Engineers Comments Regarding Condition 4- Surface Water Drainage

APPLICATION NO: AL/64/18/DOC

Registered: 20-JUL-18
Site Address: Land to rear of Woodgate Farm Hook Lane Aldingbourne PO20 3SS

Description of Works: Application for approval of details reserved by conditions imposed under planning permission AL/75/14/OUT relating to condition No.4 (Surface Water Drainage Details), 5 (Sewer

Job title:	Development at rear of Woodgate Farm
Drawing title:	Proposed Soakaway Details
Drawing number:	17-(01) 104
Client:	Guilfoyle Construction Ltd
Revision:	P2
Date of revision:	10.07.2018
Revision detail:	minor revision to included recessed cover & other changes.
Status:	PRELIMINARY

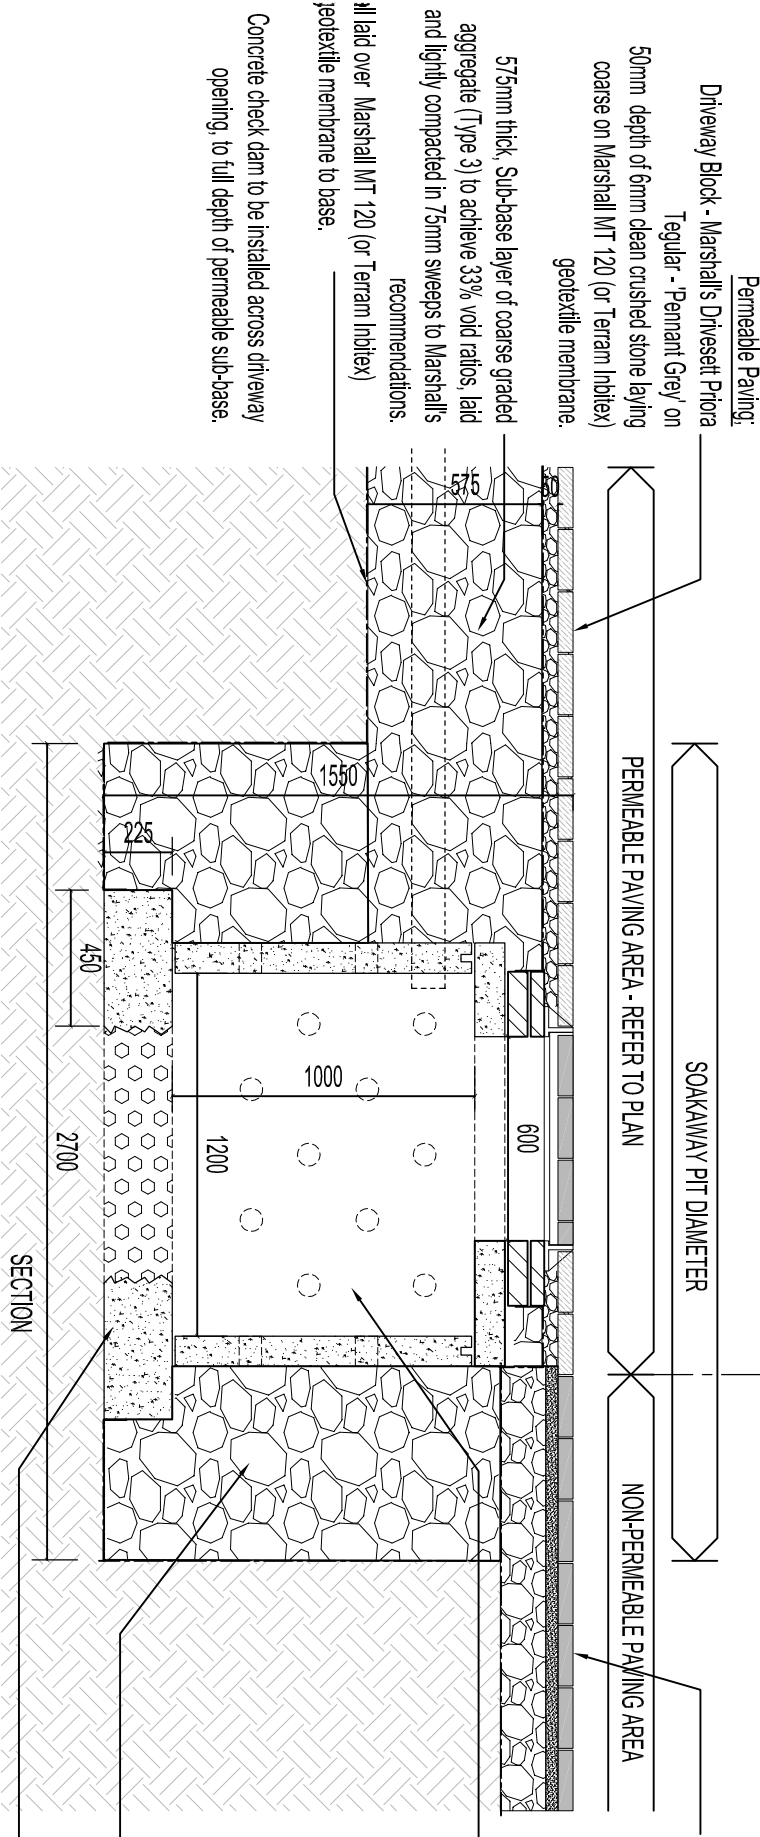
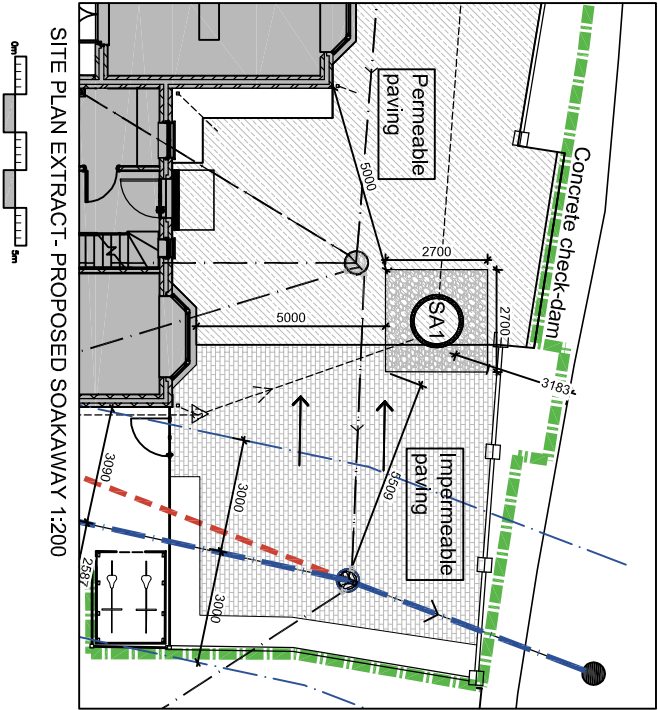
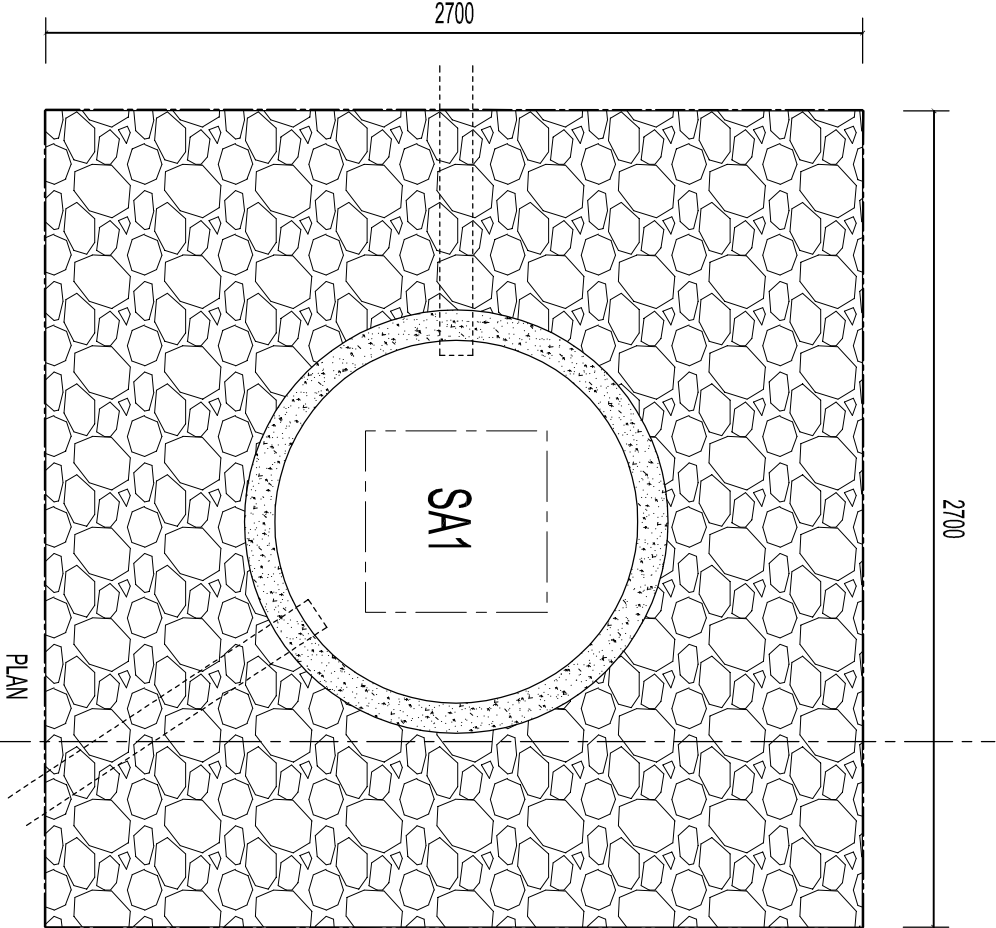
No winter groundwater testing or infiltration test results have been submitted. Please supply this information so that the proposals can be reviewed.
